February 4, 2019

**RE: 210 Biz Center
35 Anderson Creek School Rd.
Bunnlevel, NC 28323**

Application Number BCOM1901-0003

LS1

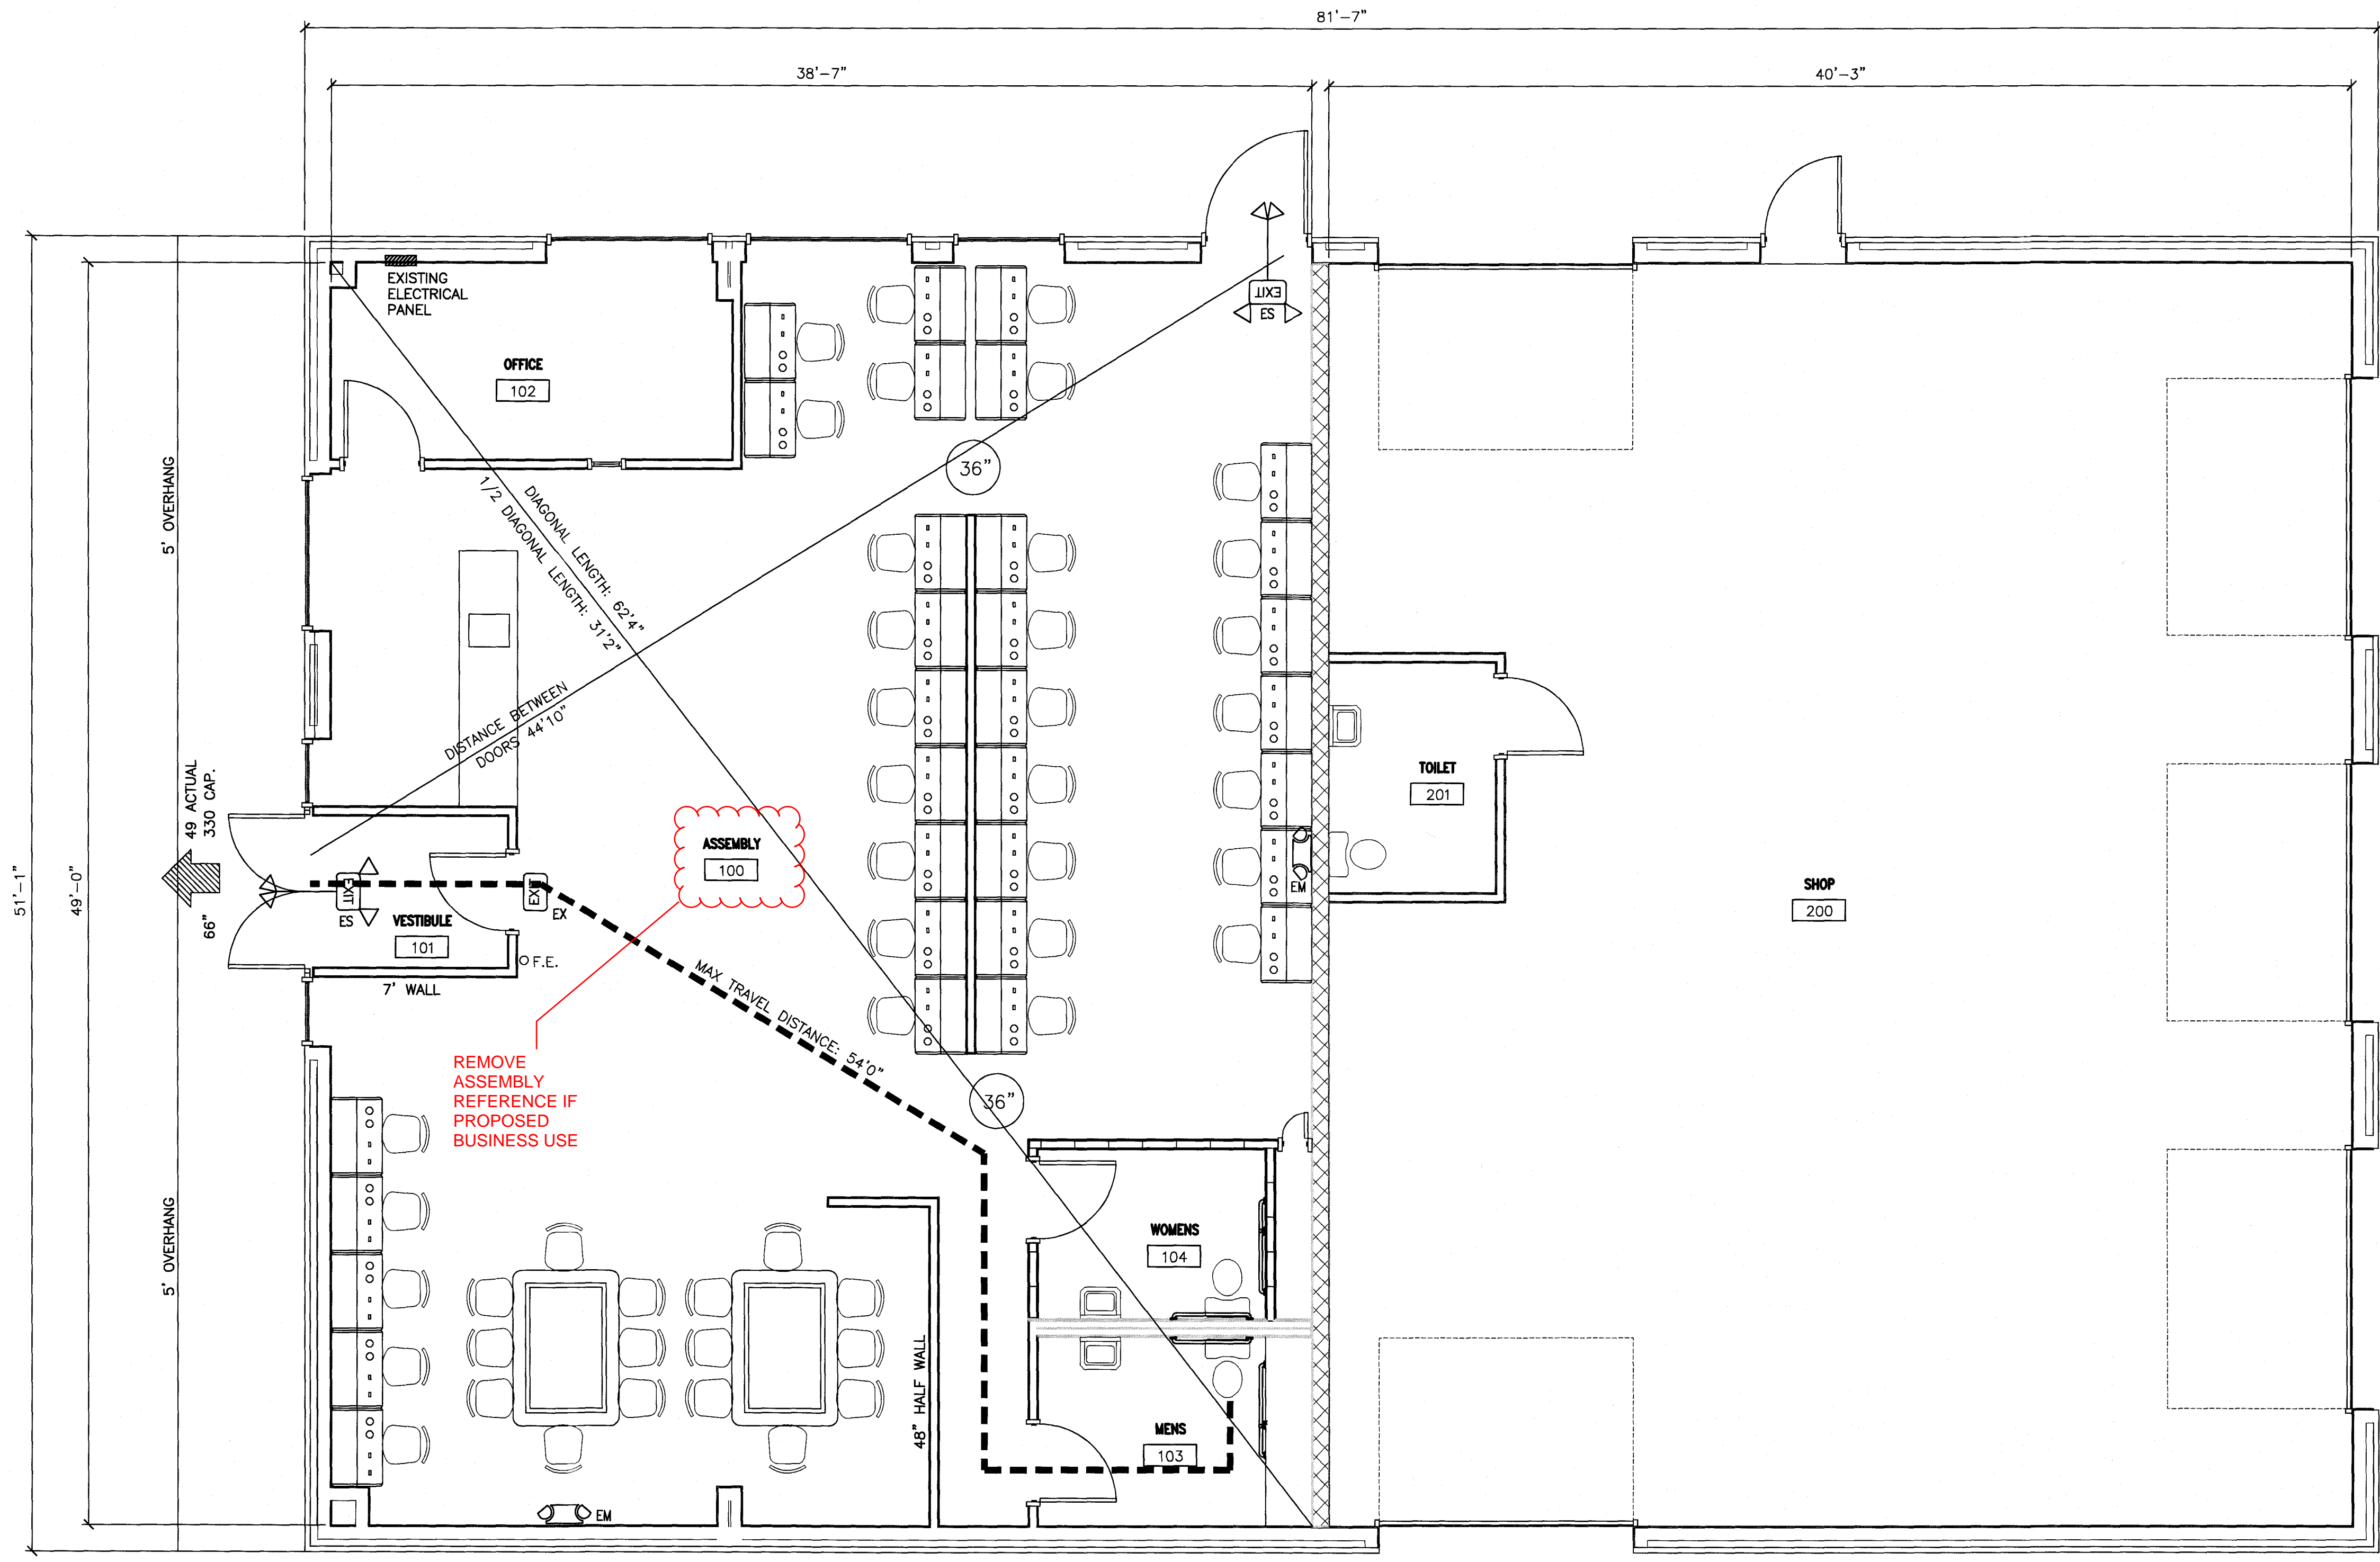
- **906.1 Fire Extinguishers**
 - A portable fire extinguisher shall be provided within a 30-foot (9144 mm) travel distance of commercial-type cooking equipment. Cooking equipment involving vegetable or animal oils and fats shall be protected by a Class K rated portable extinguisher.

- **506.1 Knox Box**
 - Keys for front entrance door shall be provided to be placed in the existing box installed on the premises.

- **1017.2 Aisles in Groups B and M**
 - The minimum clear aisle width shall be determined by Section 1005.1 for the occupant load served, but shall not be less than 36 inches (914mm).
